City of Portland, Maine - Building or Use Permit Application

Permit No: 10-0058	Issue Date:	CBL: 027 F029001
------------------------------	--------------------	----------------------------

Location of Construction: 23 Free St	Owner Name: One City Center Associates Llc	Owner Address: One City Center	Phone:
Business Name:	Contractor Name: NeoKraft Signs	Contractor Address: 686 Main St. Lewiston	Phone: 2077829654
Lessee/Buyer's Name	Phone:	Permit Type: Signs - Permanent	Zone:

Past Use: Commercial - Parking Garage	Proposed Use: Commercial / Parking garage - Install one 2' x 7' building sign and one 1'3" x 14'10 3/4" & 6' x6' building sign	Permit Fee: \$203.00	Cost of Work: \$0.00	CEO District: 1
Proposed Project Description: Install one 2' x 7' building sign and one 1'3" x 14'10 3/4" & 6' x6' building sign		FIRE DEPT: <input type="checkbox"/> Approved <input type="checkbox"/> Denied	INSPECTION: Use Group: Type:	
		Signature:	Signature:	
PEDESTRIAN ACTIVITIES DISTRICT (P.A.D.)				
Action: <input type="checkbox"/> Approved <input type="checkbox"/> Approved w/Conditions <input type="checkbox"/> Denied				
		Signature:	Date:

FLAT ALUMINUM WALL PANEL WITH VINYL GRAPHICS
SCALE: 1/2" = 1'-0" (1) REQUIRED

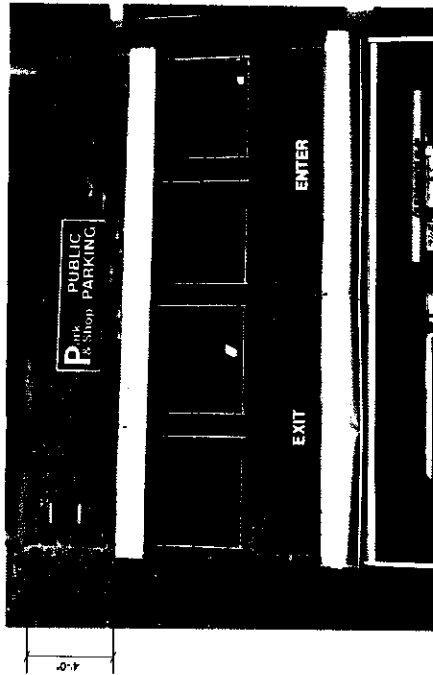
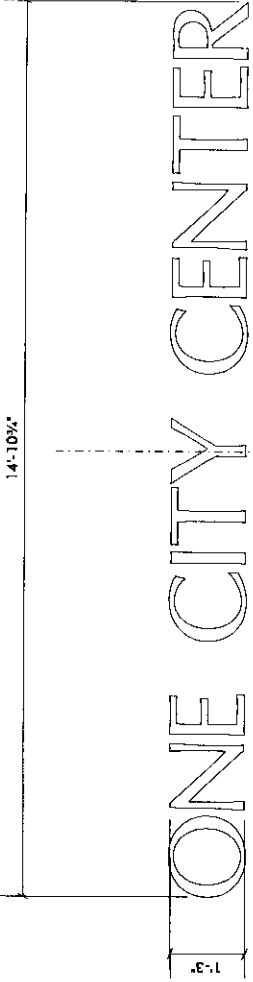
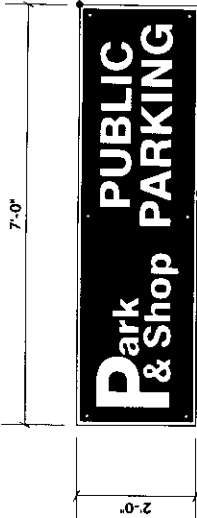
- 1) * Park & Shop sign to be as shown on revised design, submitted 2/11/2010. Background color and typeface to match that of "P" sign.
